## Rezoning Petition Review – Charlotte Tree Ordinance

**Subject:** Urban Forestry Rezoning Petition Review Summary  
**To:** Charlotte Planning, Design & Development  
**From:** Tim Porter, Chief Urban Forester  
[Timothy.Porter@Charlottenc.gov](mailto:Timothy.Porter@Charlottenc.gov)  
 704-622-4829  
**Rezoning Petition:** 2021-090

Date	Description/Status
9/23/2021	UF 2 <sup>nd</sup> review, Tim Porter
8/26/2021	UF 1 <sup>st</sup> review, Tim Porter

SHEET NUMBER
RZ101

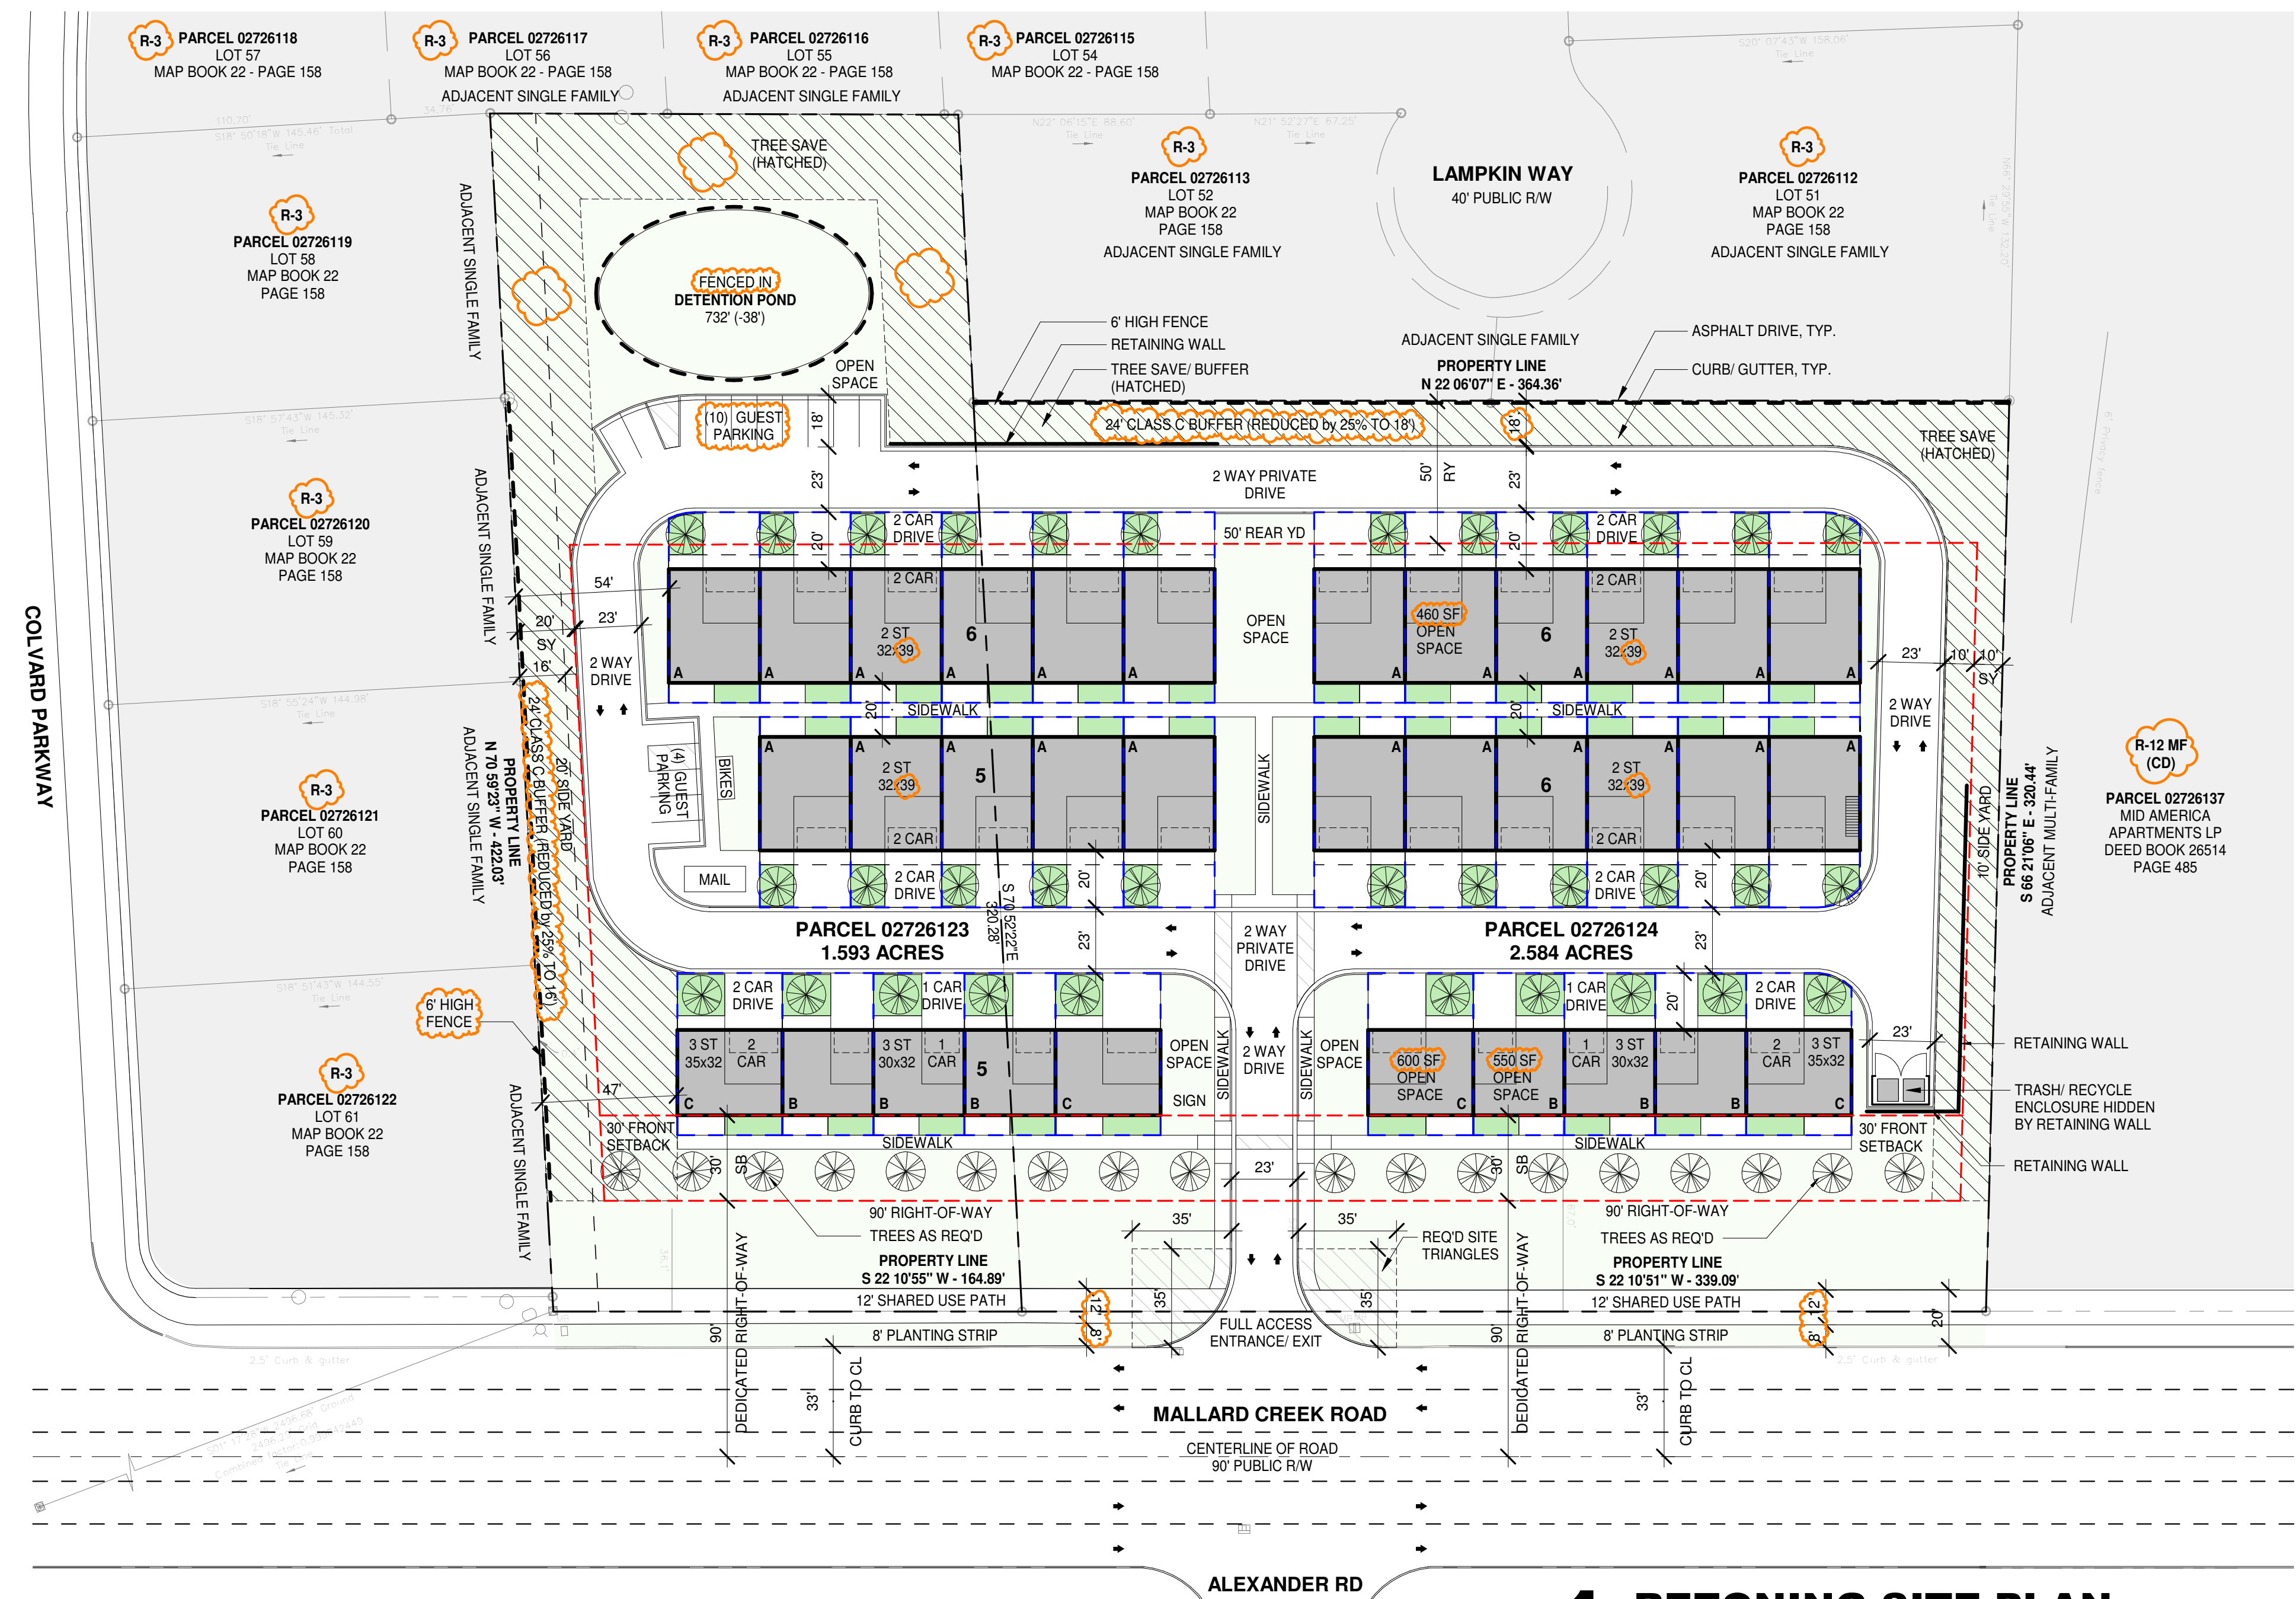
- Remove all reference planting area dimensions for internal trees. Adjustments to site design and/or planting area dimensions may be required at time of permitting
- You are required to submit a tree survey for this petition depicting existing trees in public street right-of-way. A tree survey shall be submitted identifying all trees of eight-inch (8) dbh or greater and all planted trees of (2) two-inch caliper or greater and six feet in height that grow partially or wholly within public street right-of-way.
- ~~Final tree save area requirement to be determined at time of permitting. Remove specific acreage references.~~
- ~~Change notes referencing "City Arborist Office" to "Urban Forestry"~~
